Our reference: P-591319-T6C6  
Contact: Jake Bentley  
Telephone: (02) 4732 8087

12 December 2023

**Council Response to Amendment Report - SSD-17552047 – The Edge Estate at 155–217 Aldington Road, Kemps Creek, NSW, 2178**

1 SITE / WAREHOUSE 8 PLAN
1 : 500

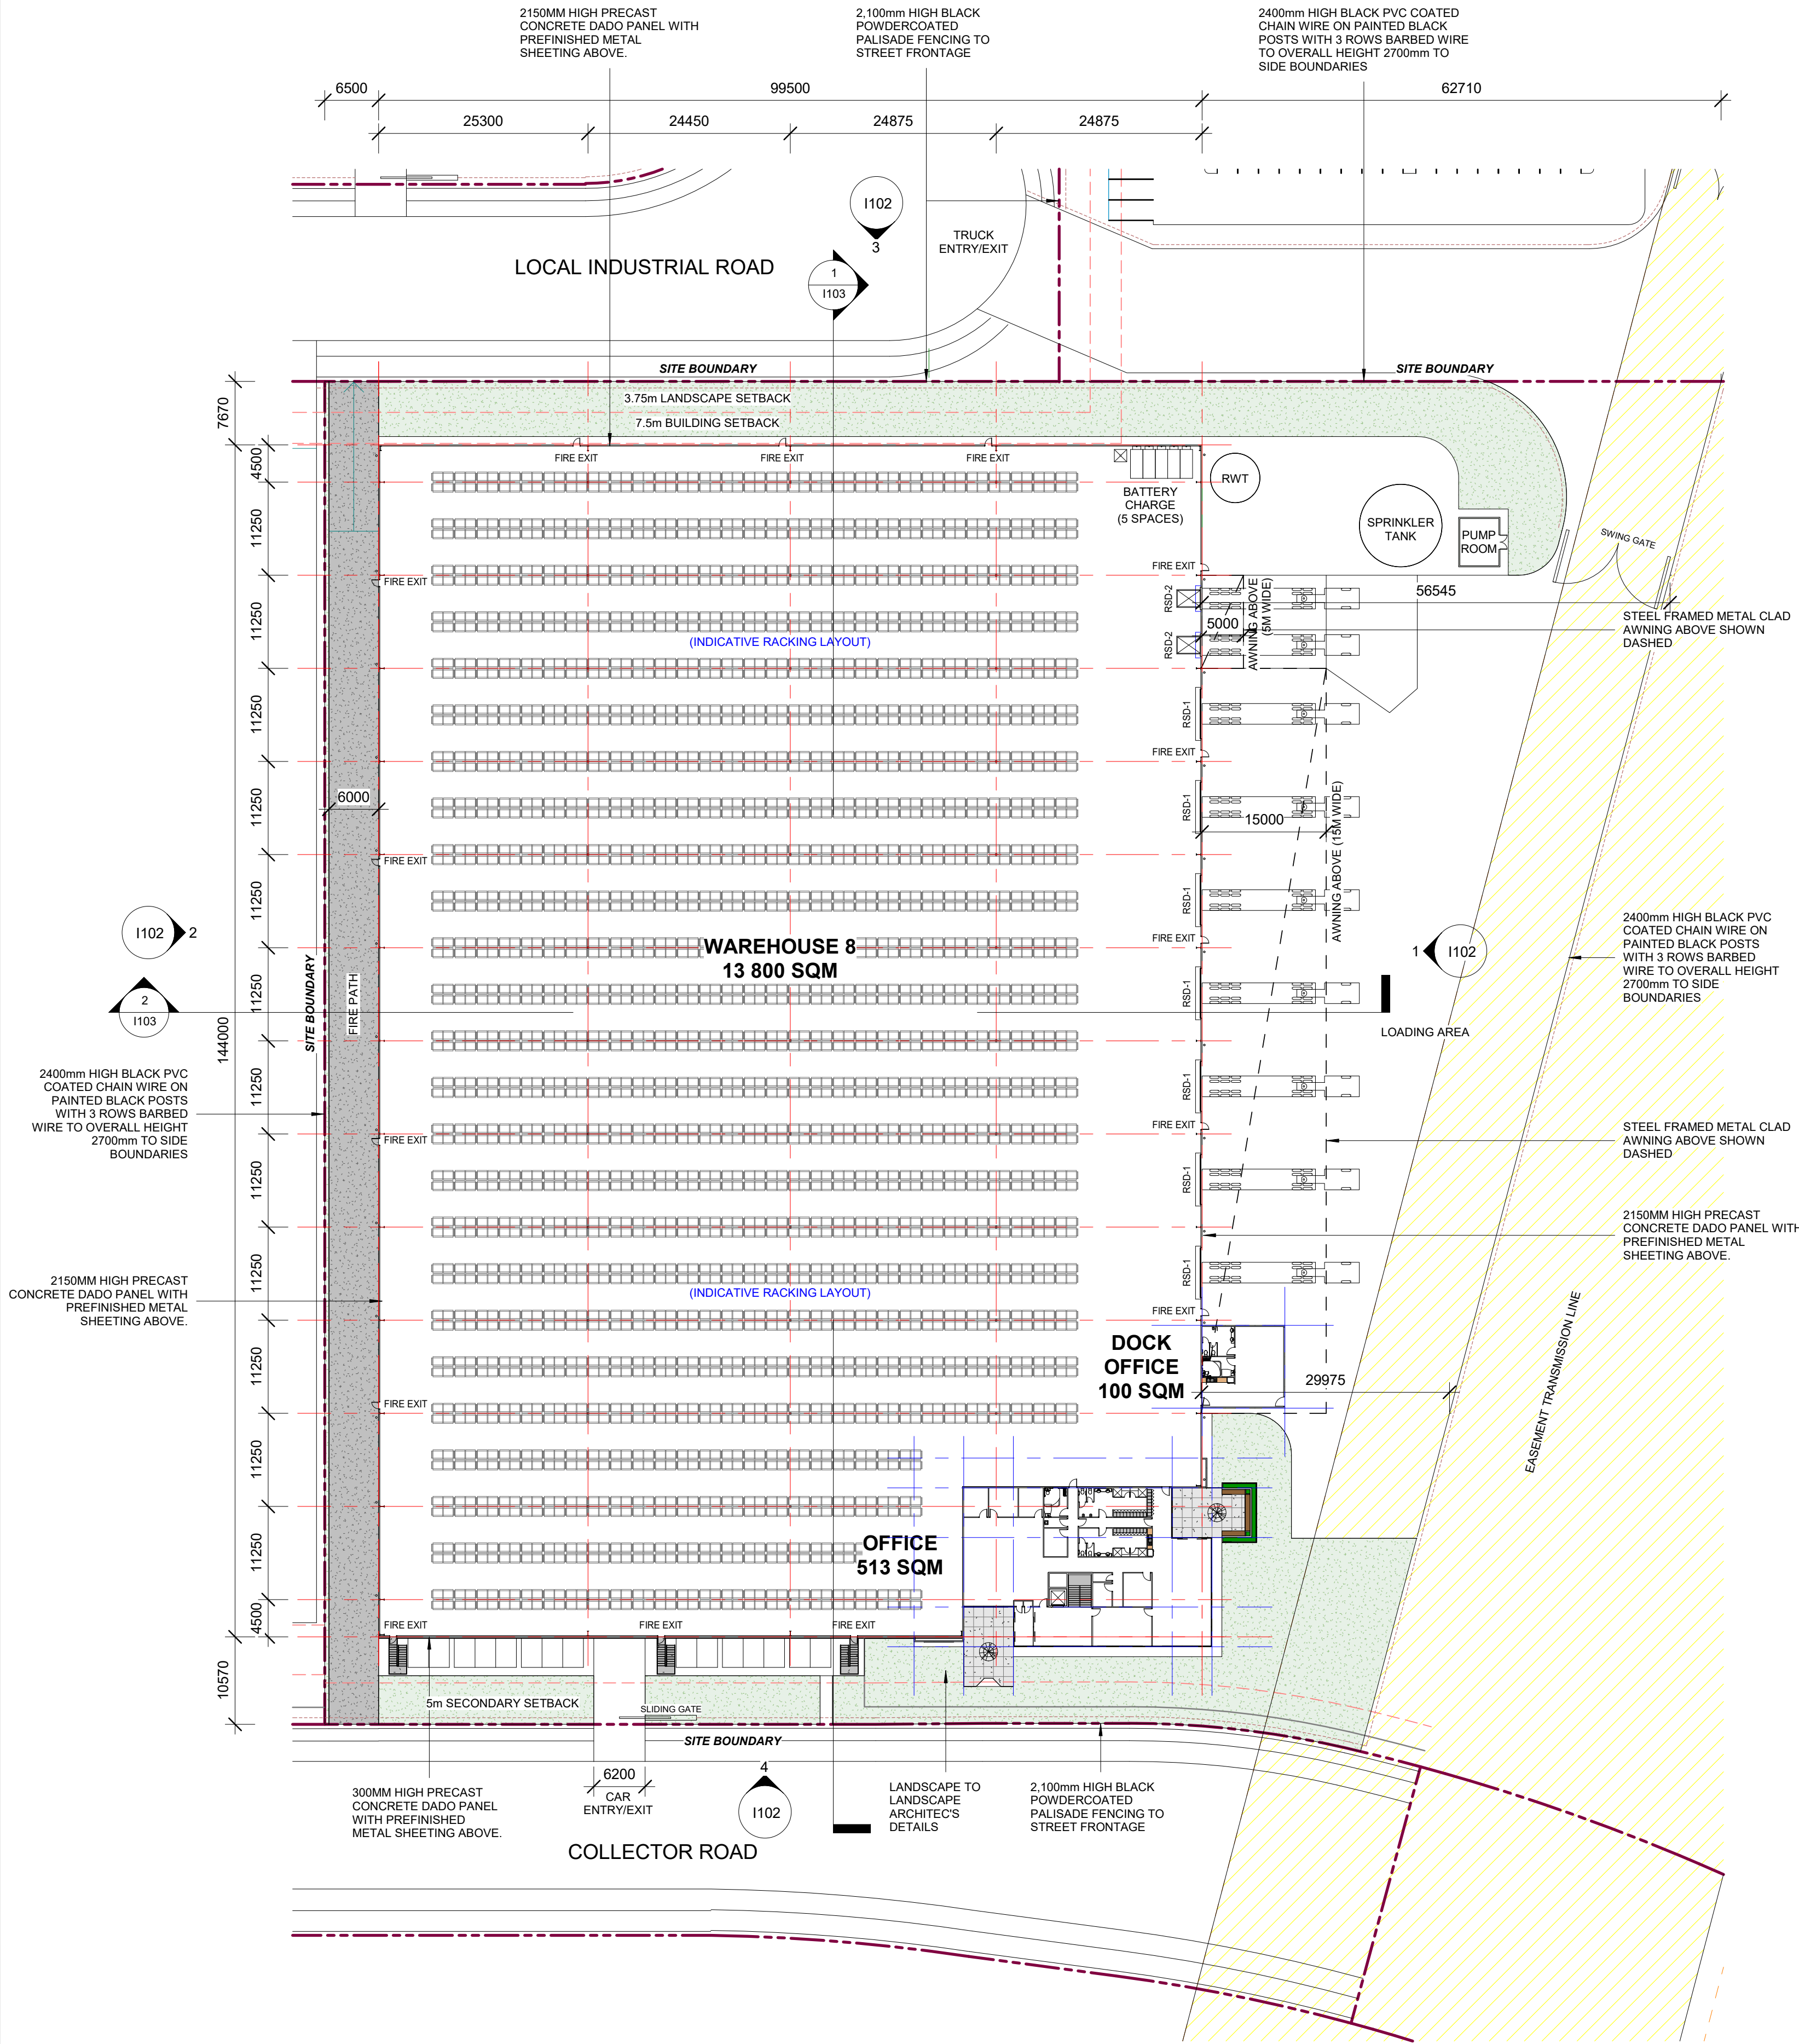
- In addition to the above, warehouses 6 and 8 have been provided with 5m setbacks (taken to be secondary street frontage setbacks) fronting Road 1. The setback classification appears to be inaccurate as parking and office areas front this road which would appear more suited to a primary street frontage and hence a larger setback. Considering the above and that

warehouses/manoeuvring areas are elevated the larger (required setback) would create increased landscape opportunity.
